CITY OF ALBUQUERQUE

RE: Coors Pavilion Subdivision Lot 4 & Portion of Lot 5
9154 Coors Blvd
Grading Plan
Engineer's Stamp Date: 3/1/2017
Hydrology File: G11D069B

Based upon the information provided in your submittal received 3/24/17, the Grading Plan is approved for Site Development for Building Permit.

CITY OF ALBUQUERQUE
PUBLIC WORKS DEPARTMENT
ENGINEERING DEVELOPMENT GROUP
COORS PAVILION SUBDIVISION
LOT 4 & PORTION LOT 5
GRADING & DRAINAGE PLAN

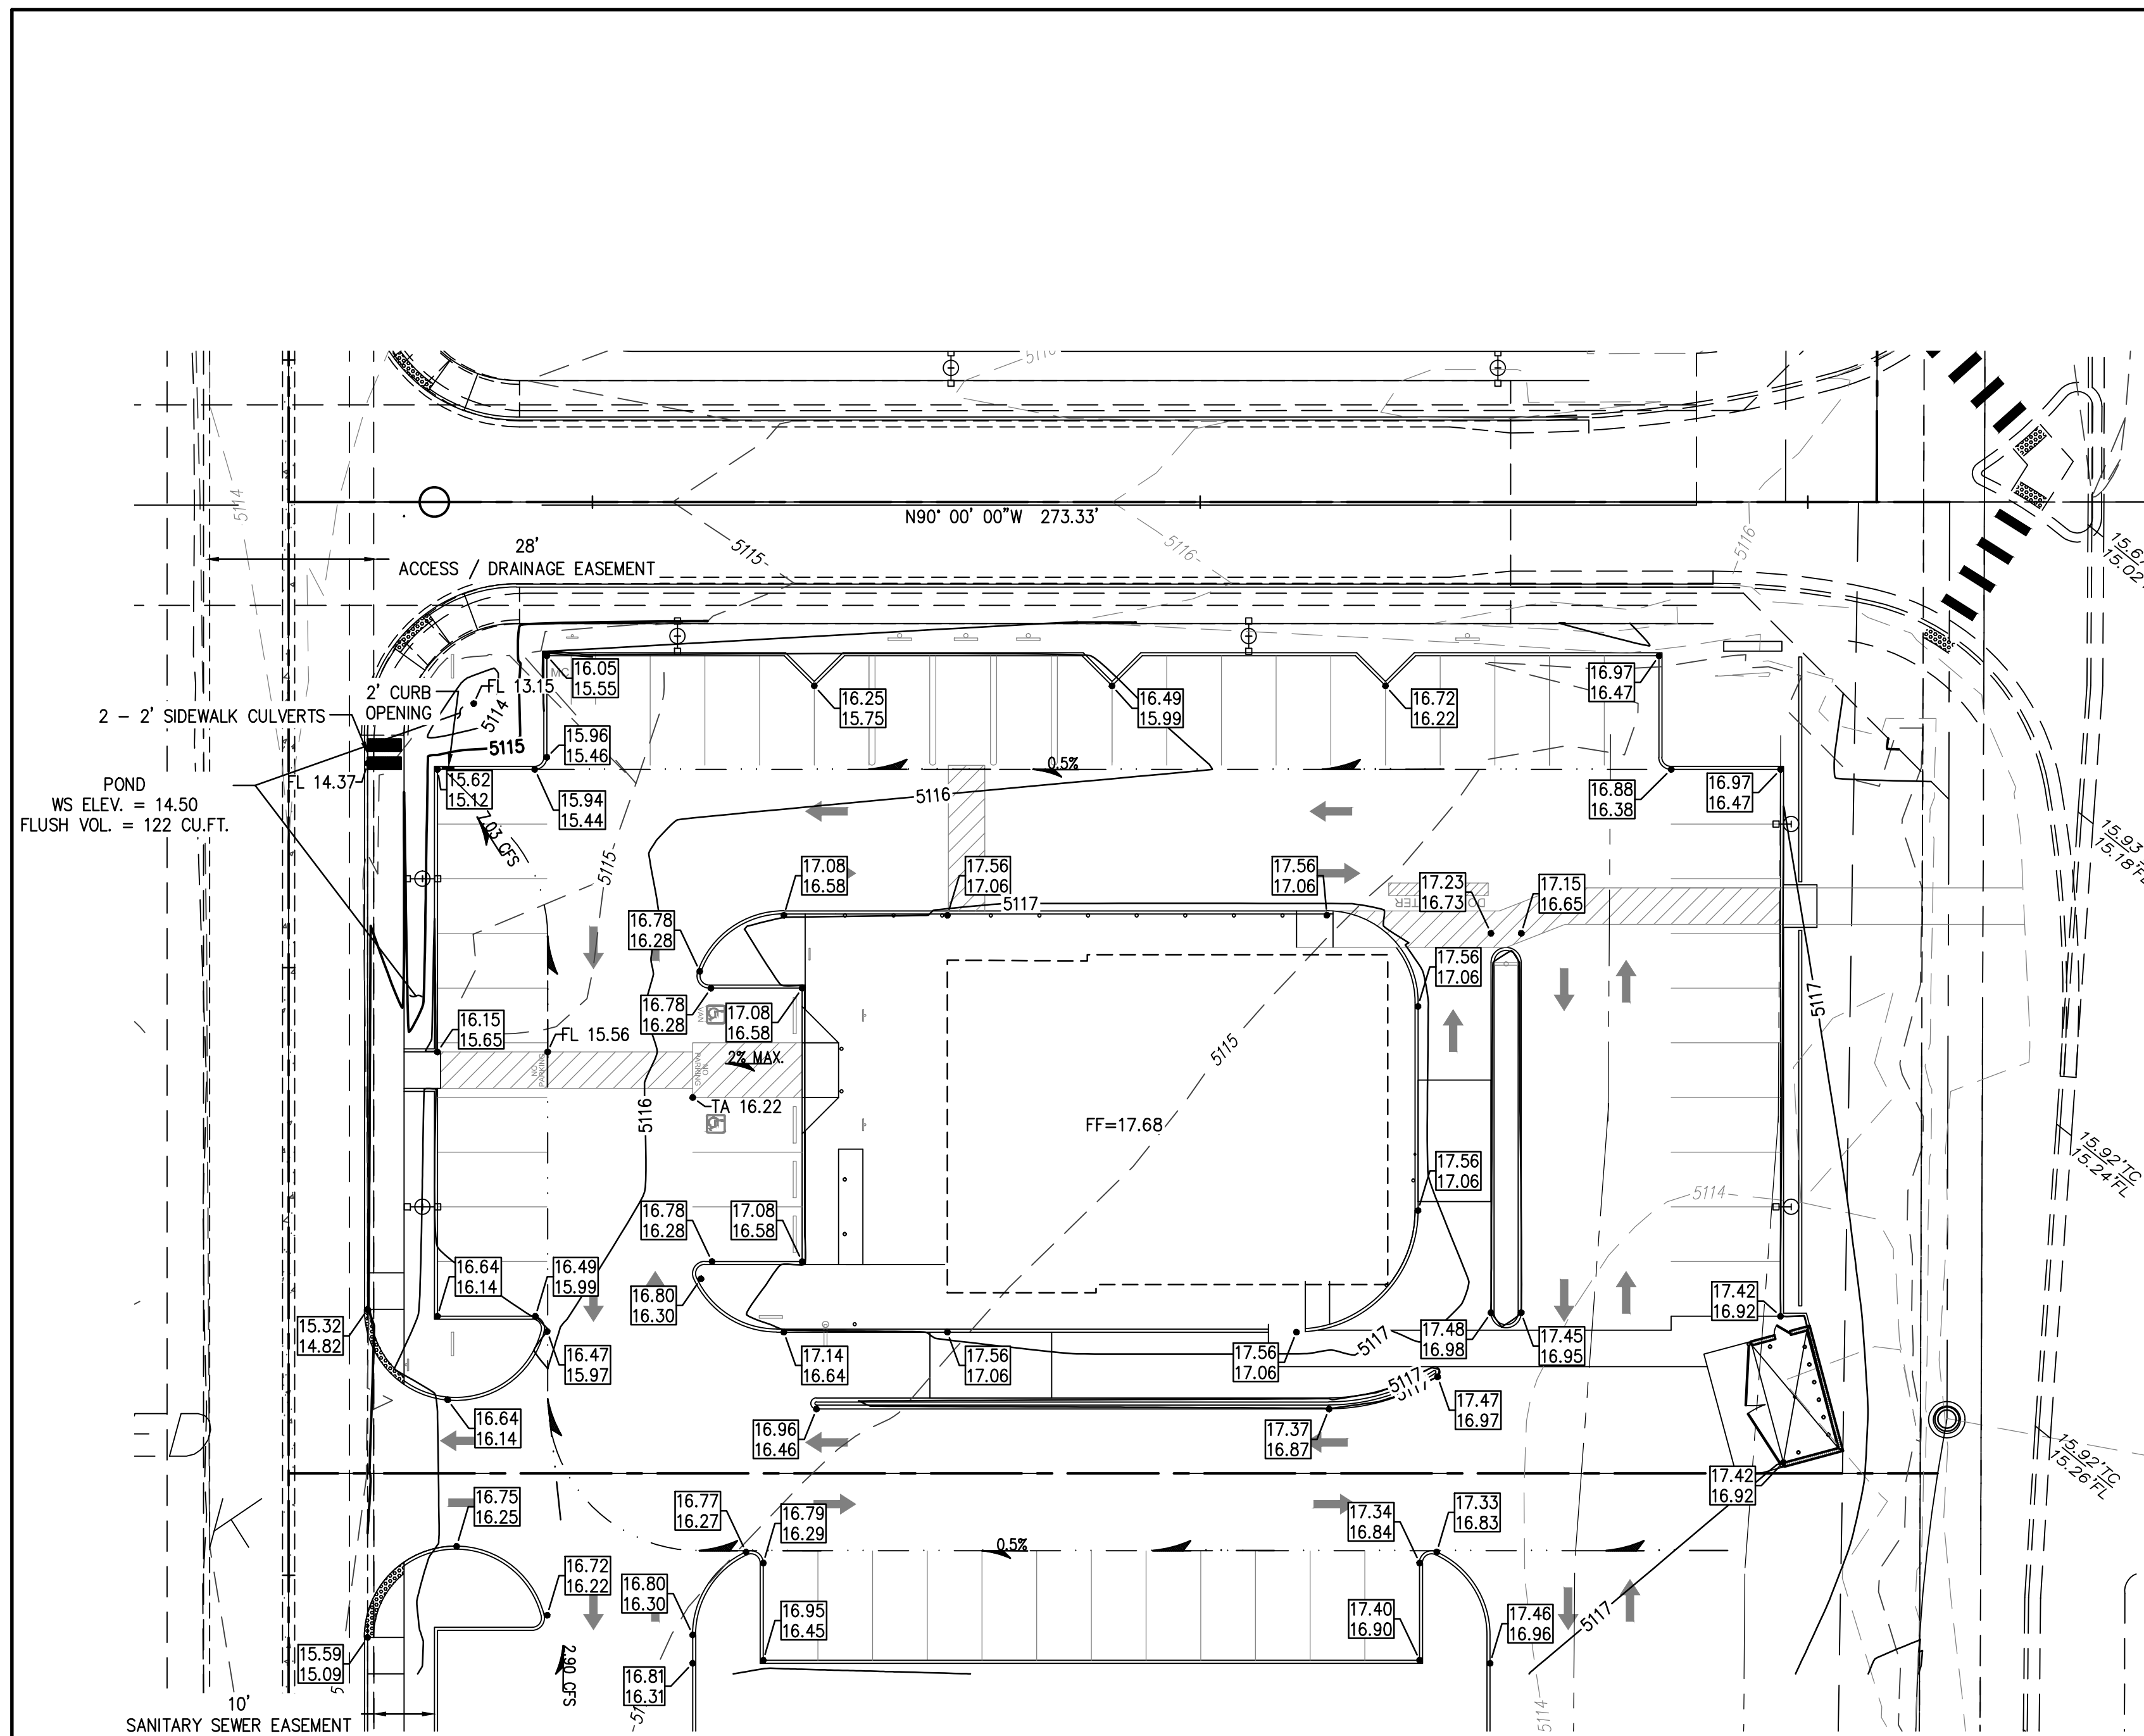
1. Prior to Final Plat, a cross-lot drainage easement will be required for Lot 4 for the benefit of Lot 5.
2. Are either of these lots being developed as restaurants? If so, provide trash enclosure containment and drainage through a grease trap and into the sanitary sewer.
